P/55/26/L

Address: Little Welbourne Church Lane Pagham PO21 4NX

Proposal: Listed building consent for the replacement of double glazed aluminum/ timber windows and doors with double glazed painted timber casement, sprung sash windows and matching French doors.

DRAWING TITLE
Proposed Window / Door Schedule

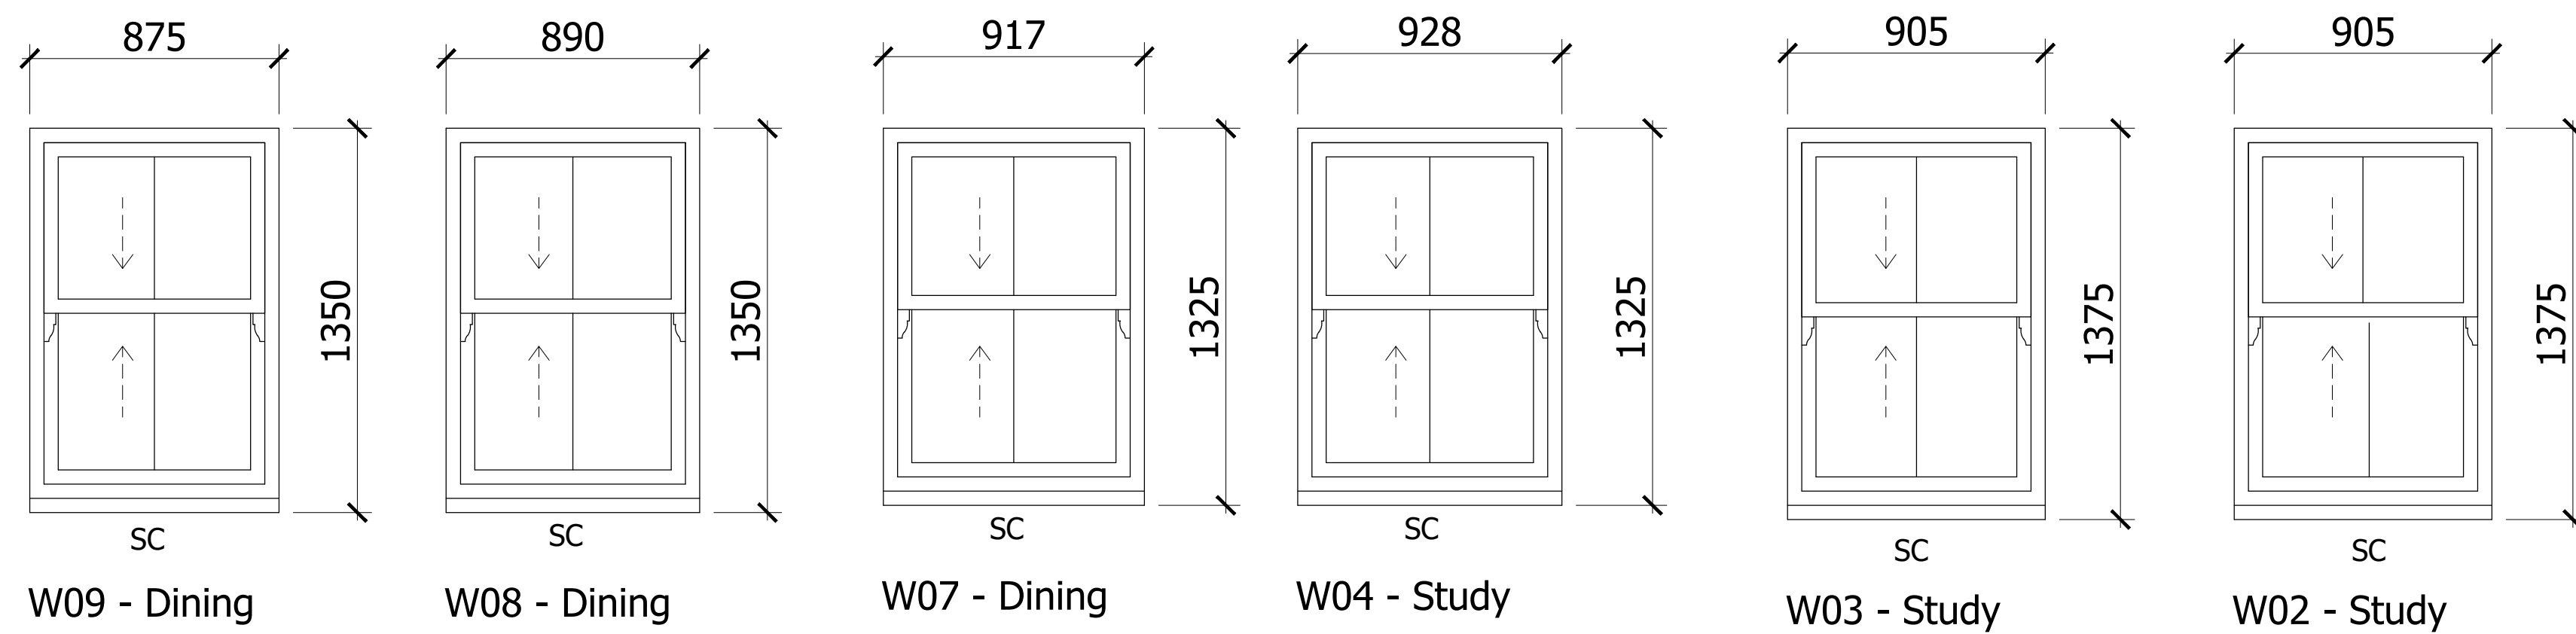
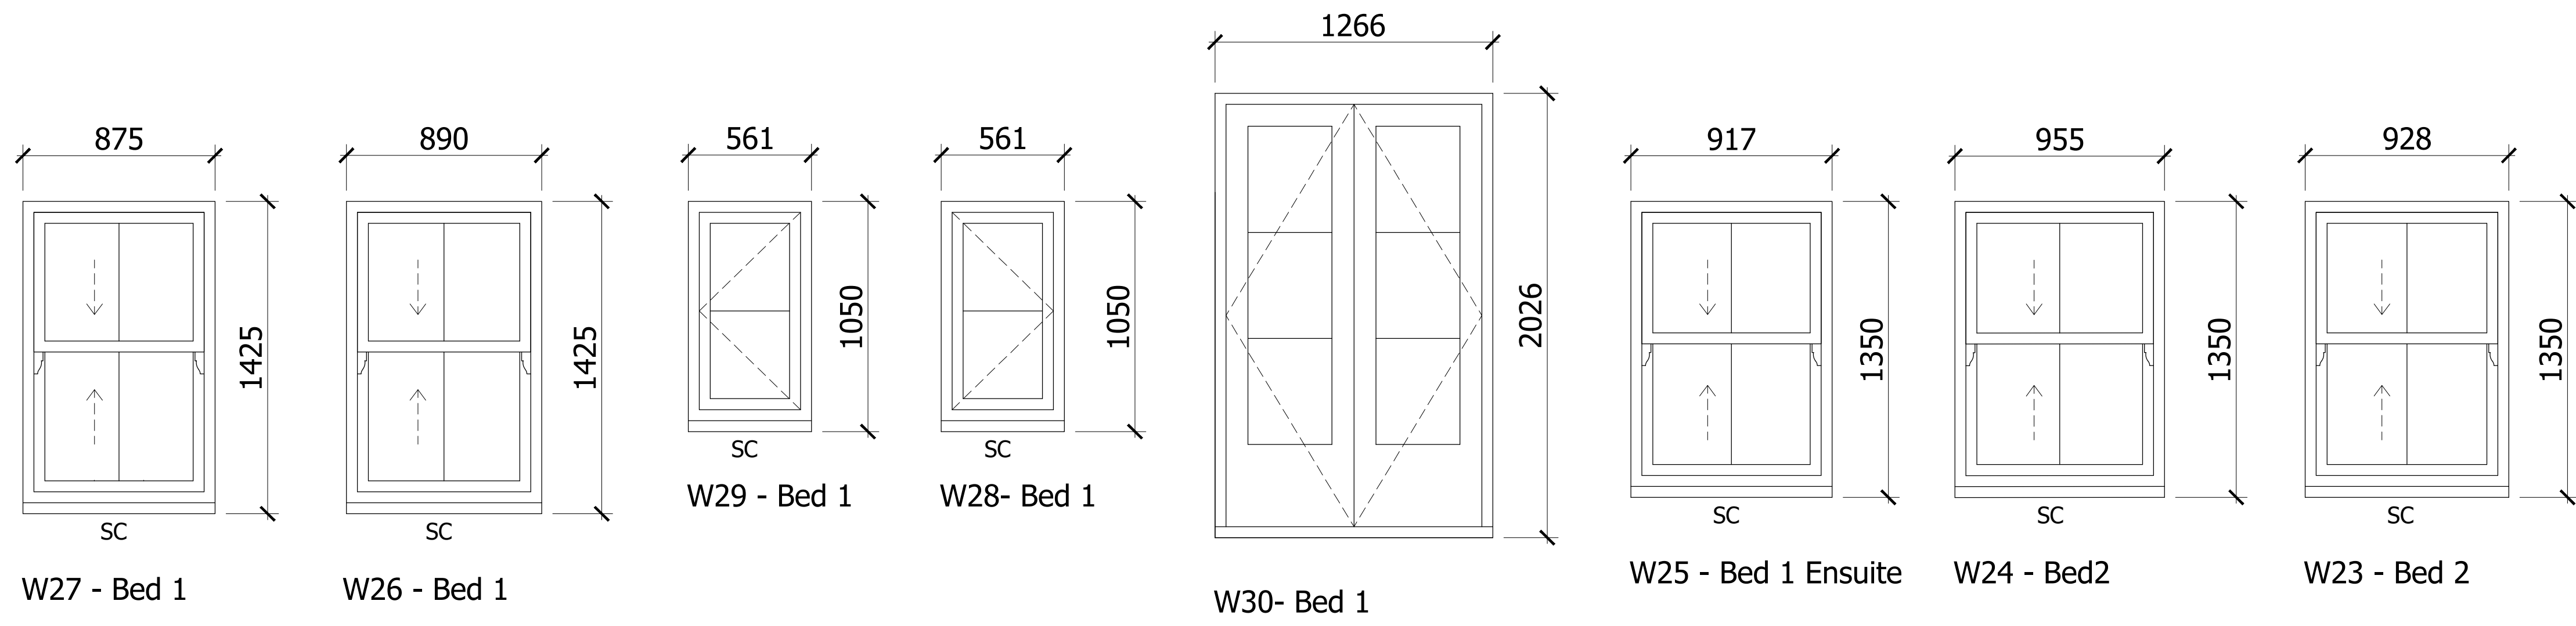
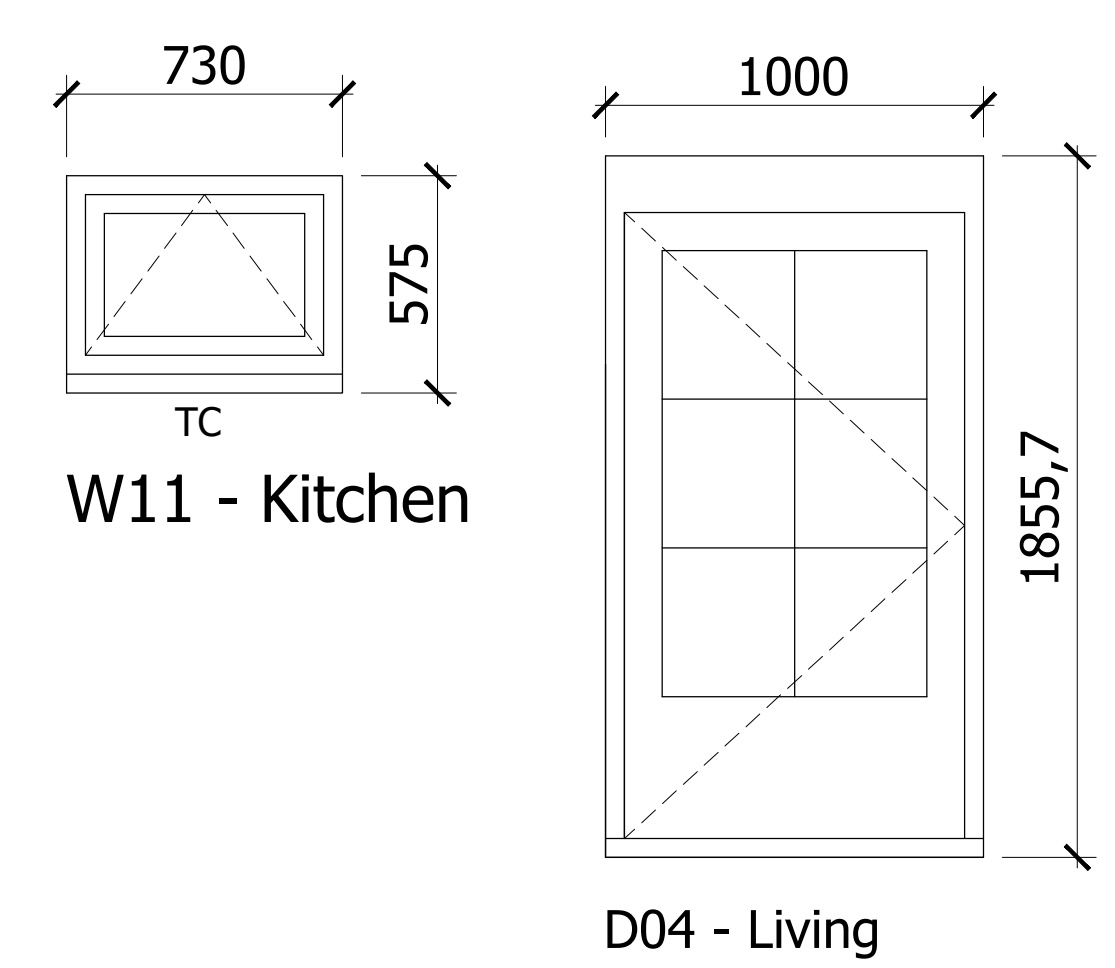
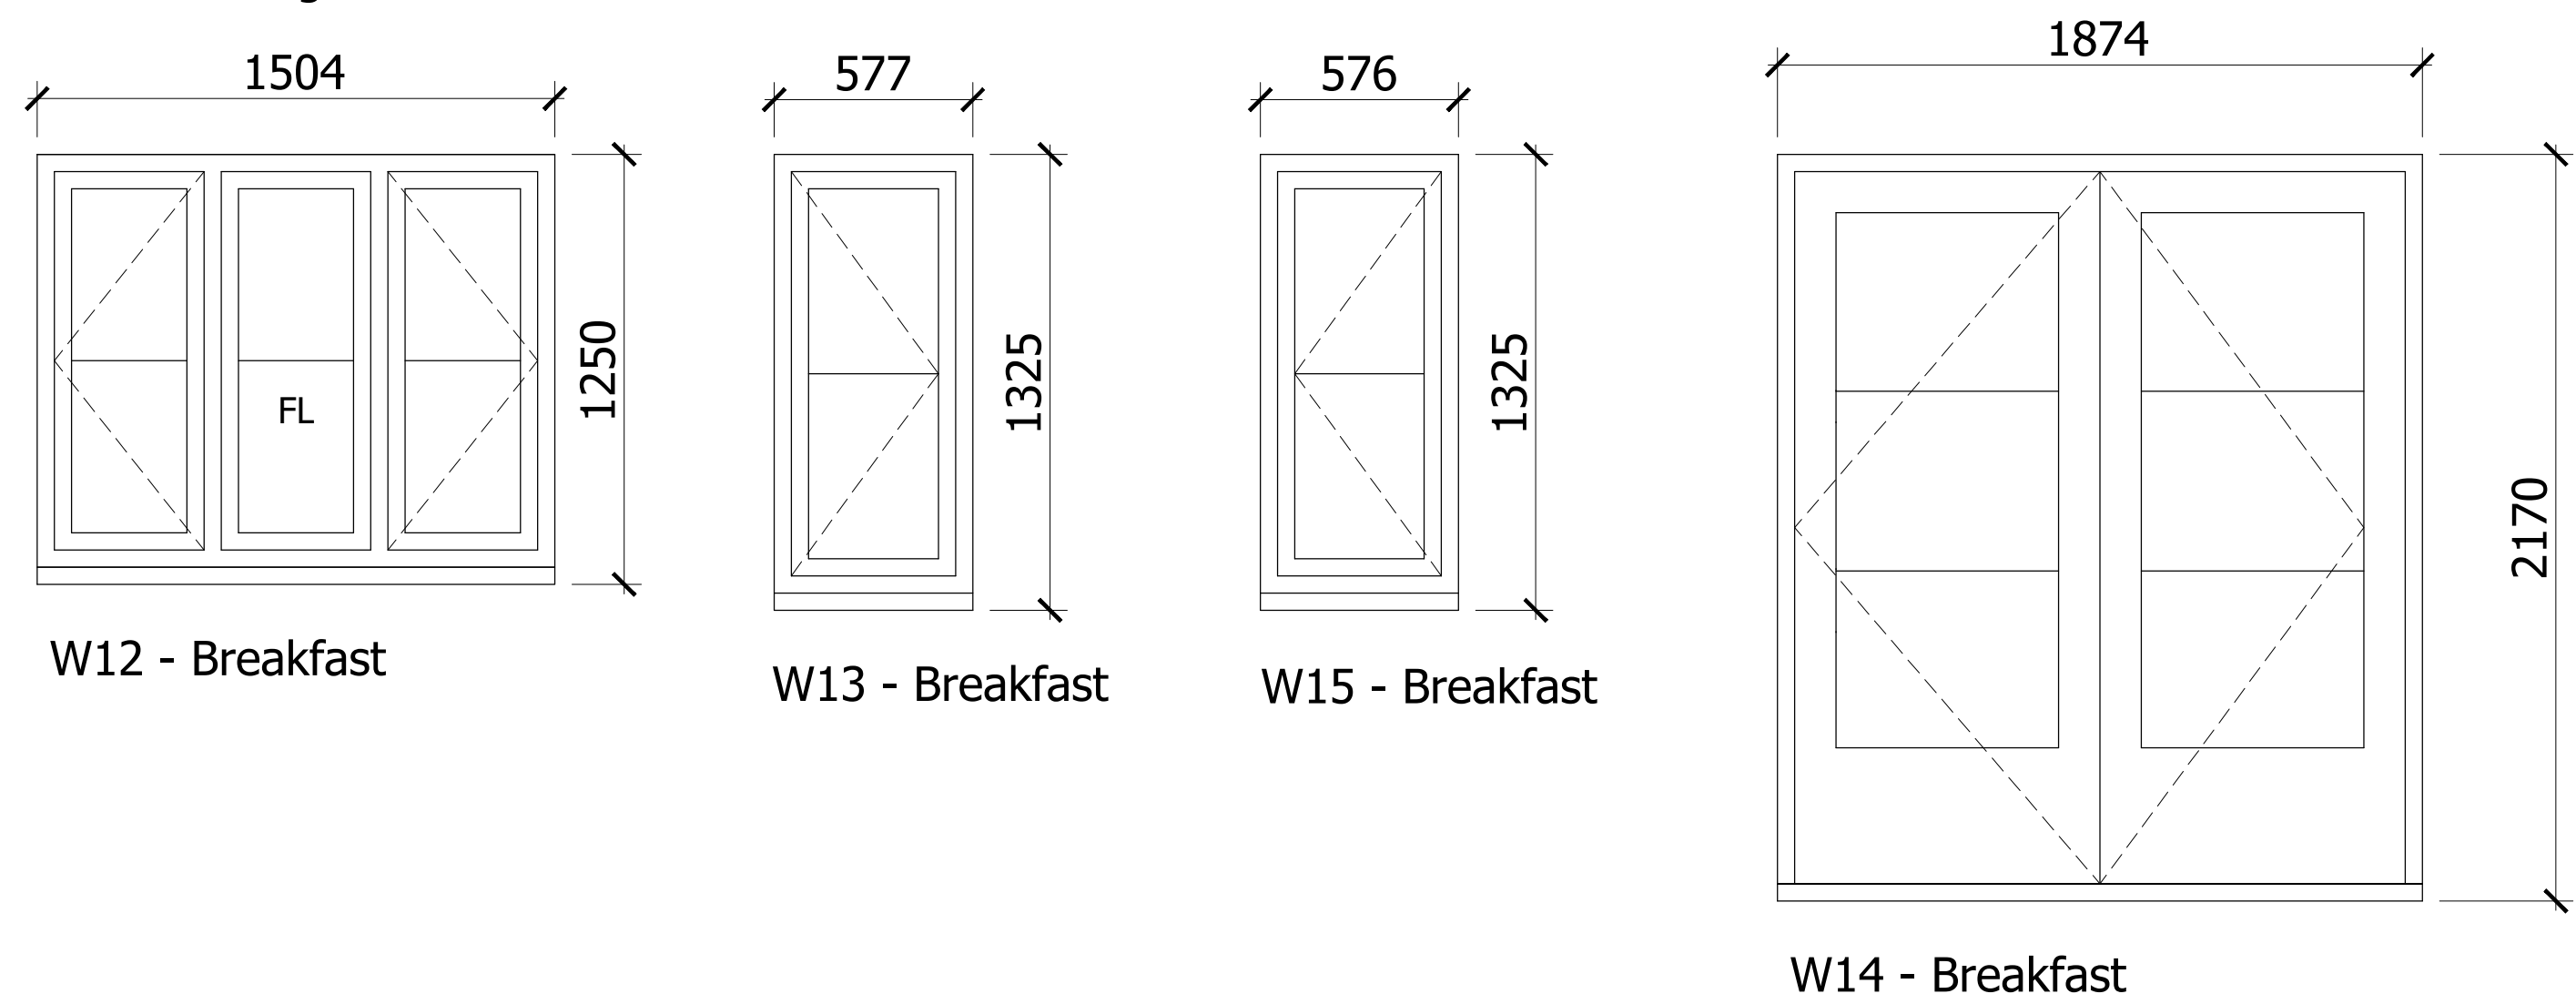
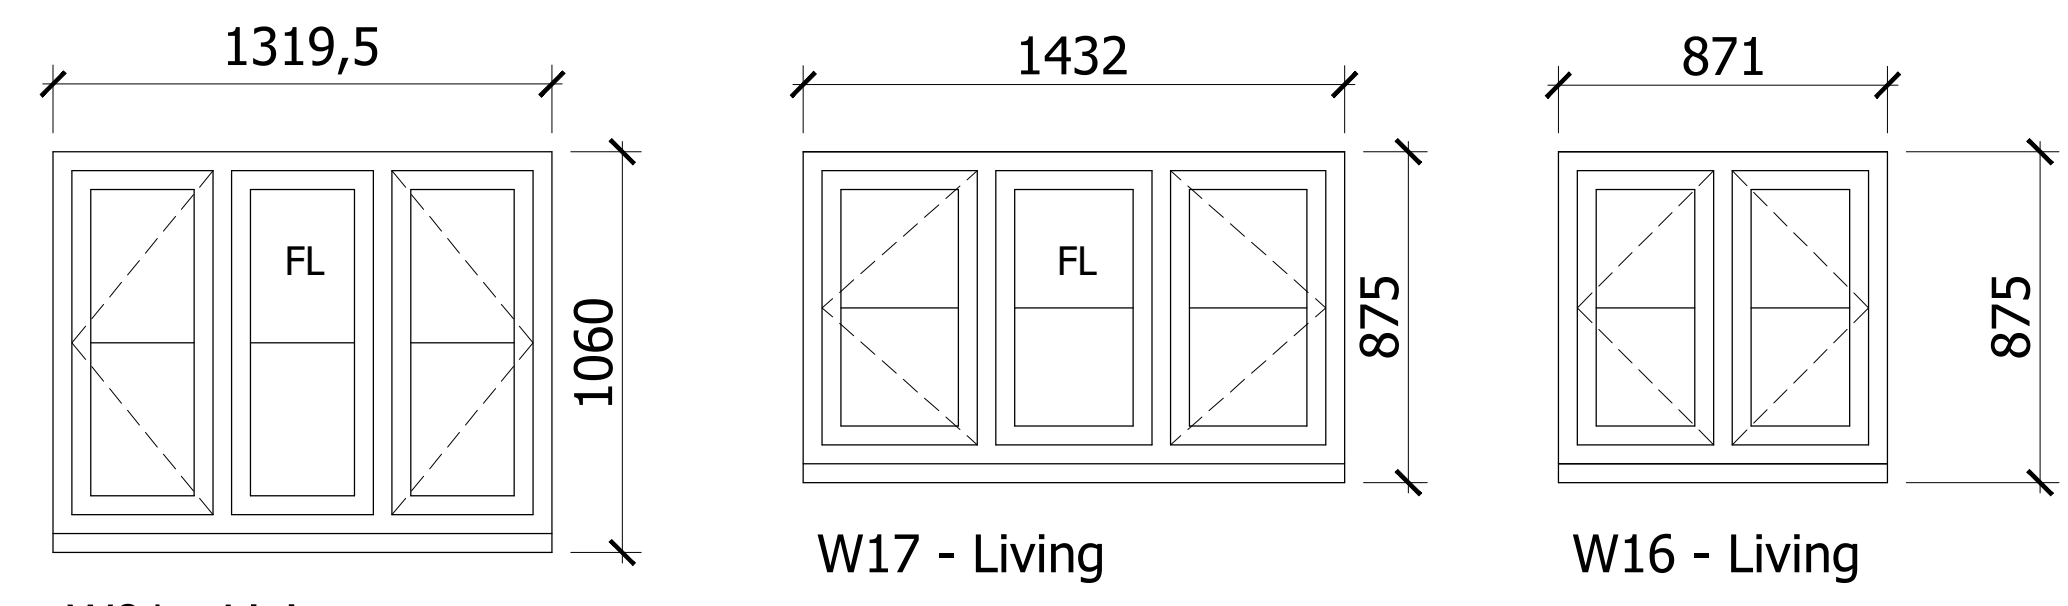
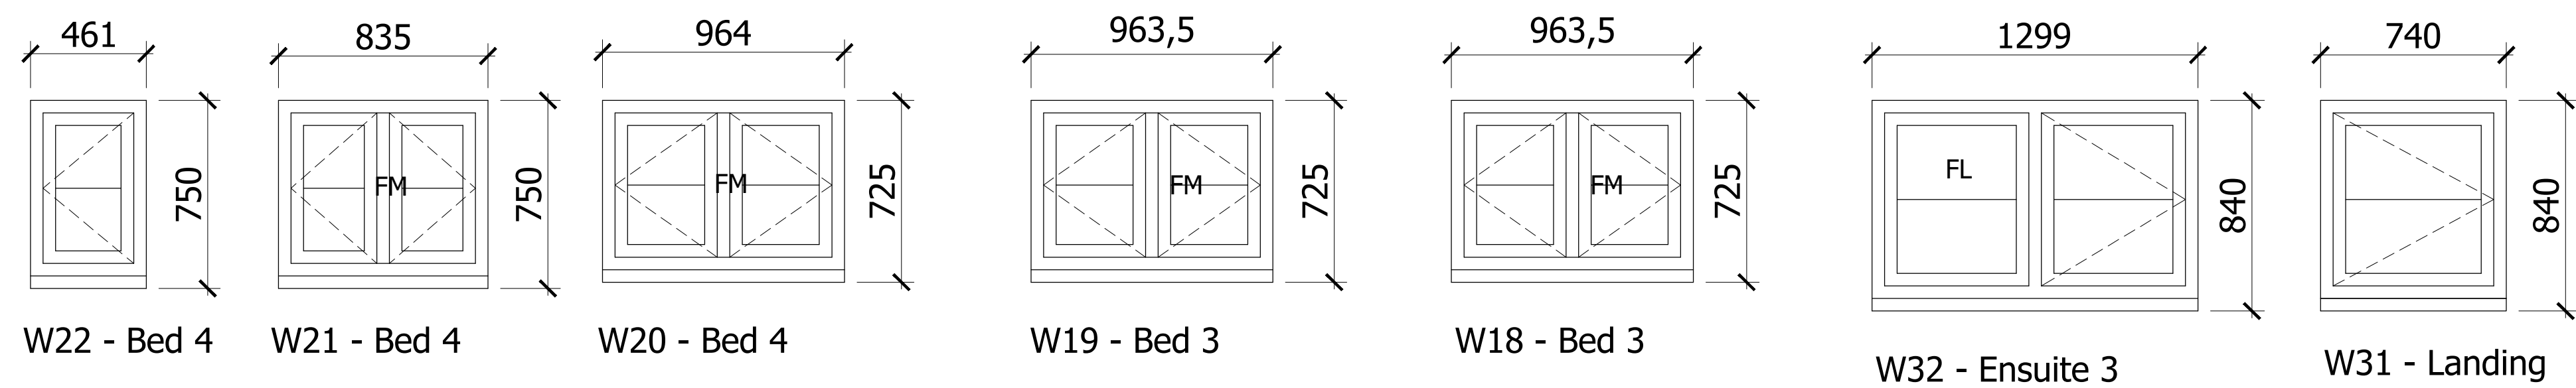
However, the proposed scheme does not adequately follow the above guidance. The submitted windows appear to incorporate standard or relatively thick double-glazed units, rather than slimline heritage units. Such construction lacks the subtlety of traditional glazing profiles and results in visibly heavier sections. This not only reinforces the appearance of modern joinery but also alters the proportions and detailing of the window design.

Traditionally, glazing bars form an integral part of the window structure rather than being applied. Whilst it is positive that integral glazing bars are proposed, they appear overly robust, resulting in a heavier visual appearance than would be characteristic of historic examples. Based on the submitted details, the glazing bars etc. appear noticeably thicker than traditional profiles. It is also unclear why timber beading is proposed in place of traditional putty glazing, which would typically provide a finer and more authentic finish.

This type of double glazed unit and window design is therefore not appropriate for a listed building and is considered to cause harm. The proposal is such that the impact can be described as causing less than substantial harm in accordance with paragraph 215 of the NPPF (2024). As such, you will also need to consider the public benefits that the development may achieve as part of your assessment of the application, along with the contents of section 16 of the Planning (Listed Buildings and Conservation Areas) Act 1990 (as amended).

However, it is considered that a more appropriate solution could be achieved through revisions to the detailed design.
